# CITY OF ALBUQUERQUE

**Re: Tuscan Village / Sauvignon Phase III, Lots 1-5,  
SIA/Release of Financial Guarantee—Not Accepted  
Engineer's Stamp date 01-11-12 (E22/D007G)  
Certification date 07-12-12**

CITY OF ALBUQUERQUE
DEPARTMENT OF MUNICIPAL DEVELOPMENT
SAUVIGNON PHASE III / TUSCANY VILLAGE
GRADING PLAN

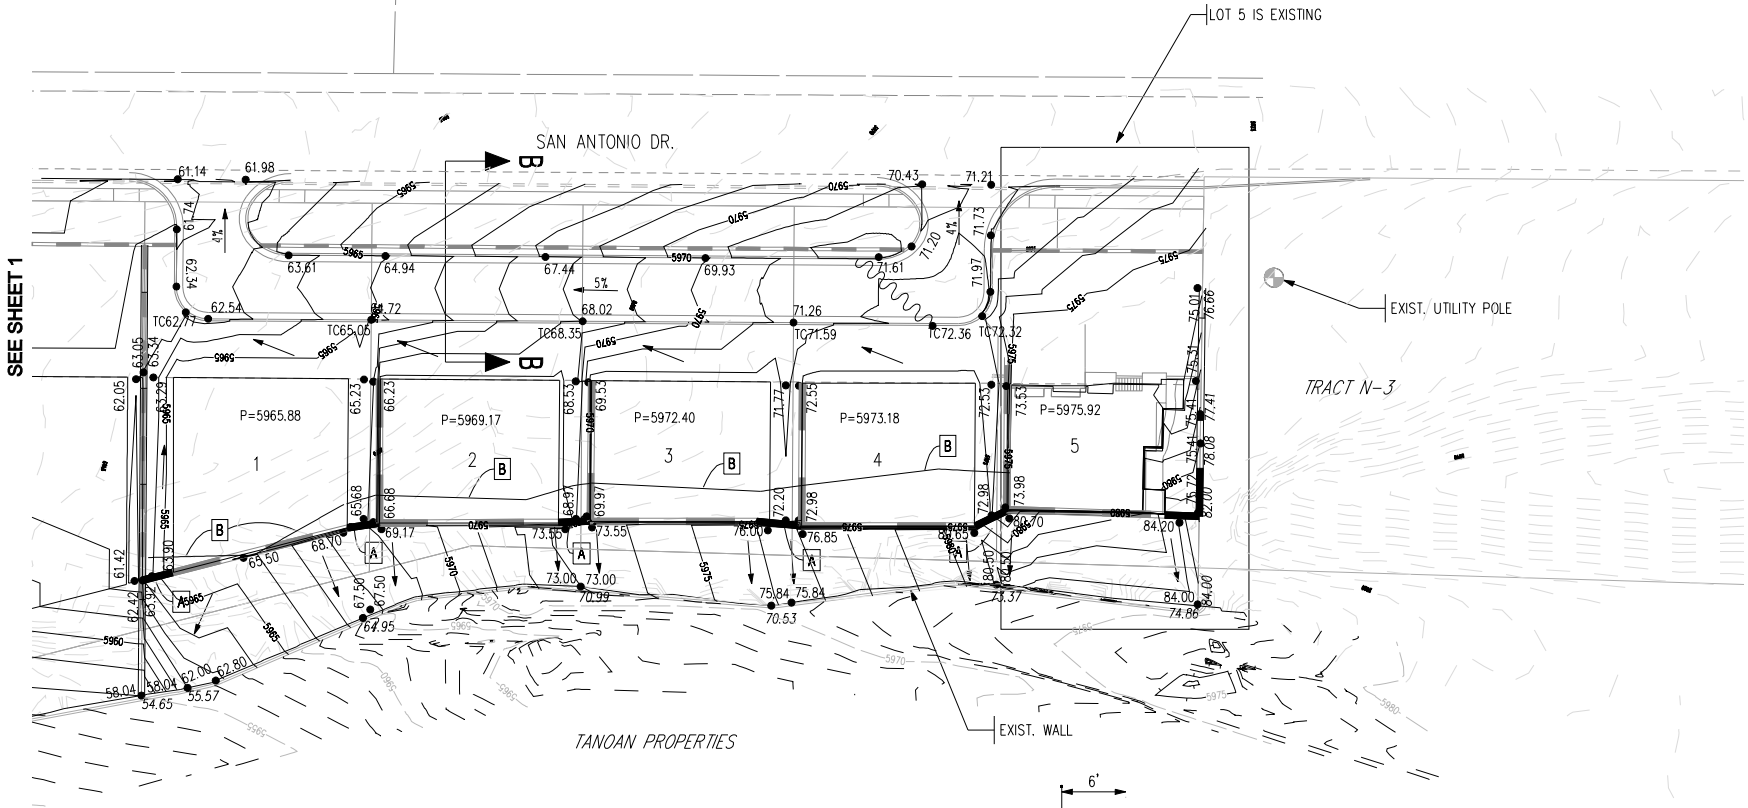
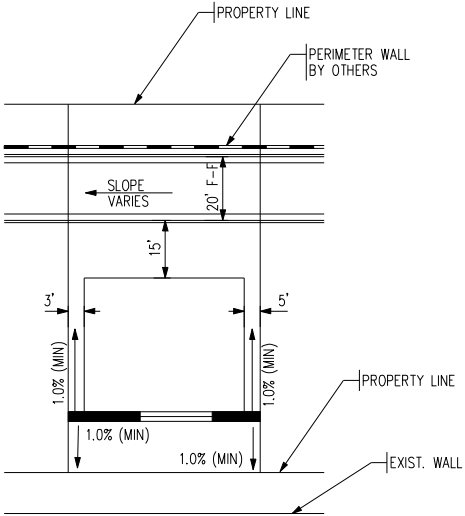
1. Please include the work order number with all release of financial guarantee requests.
2. Provide additional elevations within the slope tie area in the rear yards. An approximate location, of this slope tie, would be helpful for this certification.
3. Please provide the finished floor elevation for the house on lot 5, not the pad elevation.
4. Please provide top of wall and bottom of wall elevations for all wall constructed. Top of wall and bottom of wall will need to be certified at time of release of financial guarantee.
5. Due to retaining walls being a part of the homeowner responsibility the certified plan will need to be in future building permits for this subdivision.
